From: Brian Banister [REDACTED]
Sent: 22 June 2022 14:39
To: Planning.Responses <Planning.Responses@arun.gov.uk>
Subject: Re: Planning Consultation on: AB/82/22/L

Thankyou for the consultation. The comments of the **Arun District Conservation Area Advisory Panel** are as follows:

Application No: AB/82/22/L
Registered: 17th March 2022
Site Address: 45 Tarrant Street Arundel BN18 9DJ
Grid Reference:
Description of Works: Listed building consent to create new en-suite bathroom in 3rd floor bedroom, storage cupboard on 3rd floor landing and new garden room.

client	project	drawing	date	drawn	drawing no	revision
Chris Thornton	New Garden Room & En-suite at The Old Brewery, 45-47 Tarrant St Arundel, BN18 9DJ	Proposed Section A-A	Feb 22	pd	0364 / 104	-
			scale	CAD file name:		
			1:50 @ A3

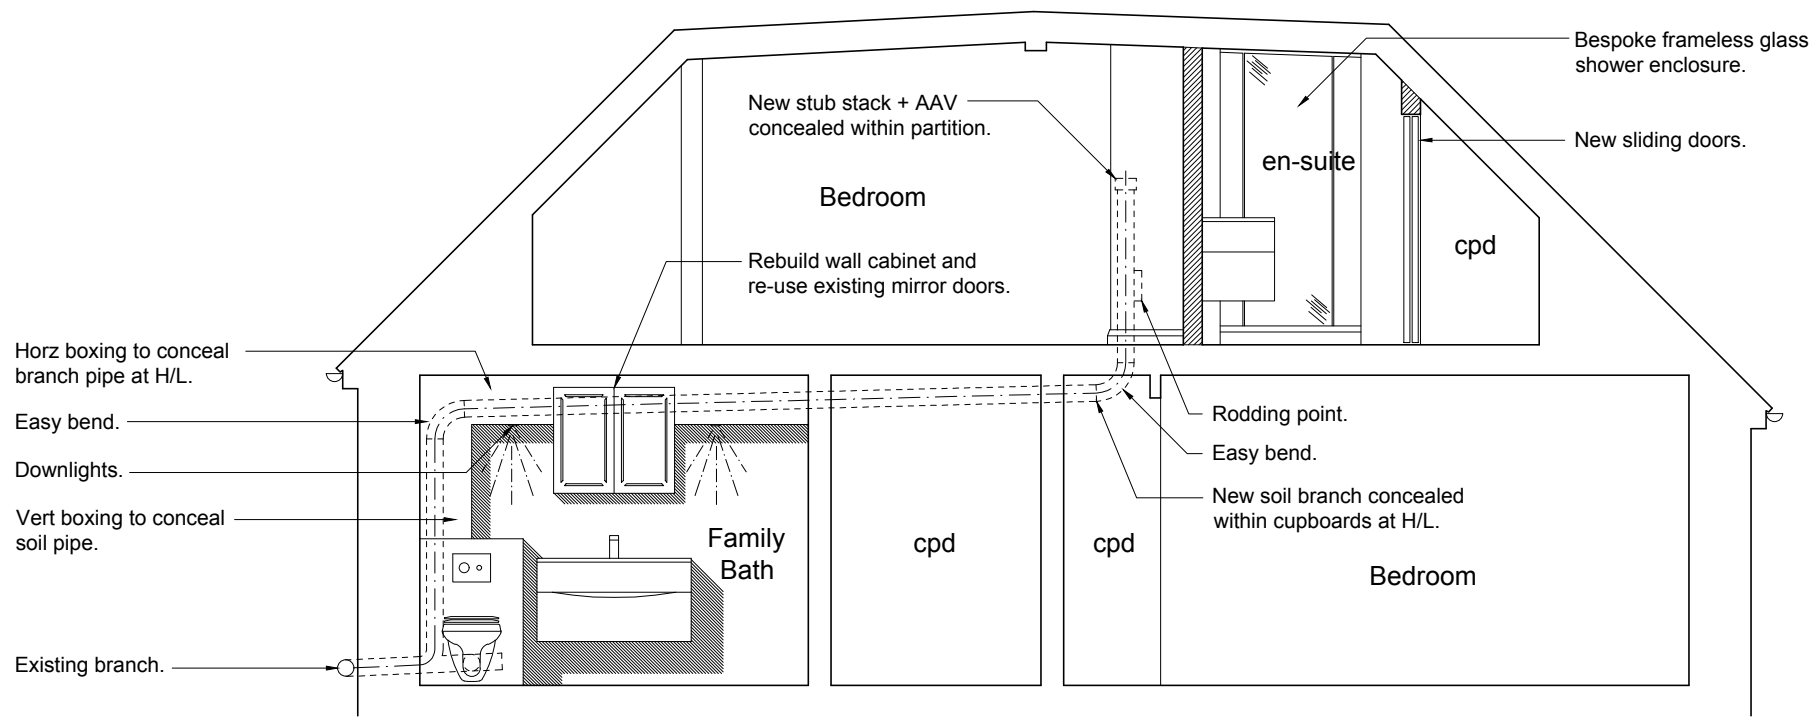
Section 72 of the Listed Building Act 1990 applies and in this regard the Panel's view is that given the modest size of the garden room and the inconspicuousness of the slate vent there will be no adverse impact on the character or appearance of the conservation area.
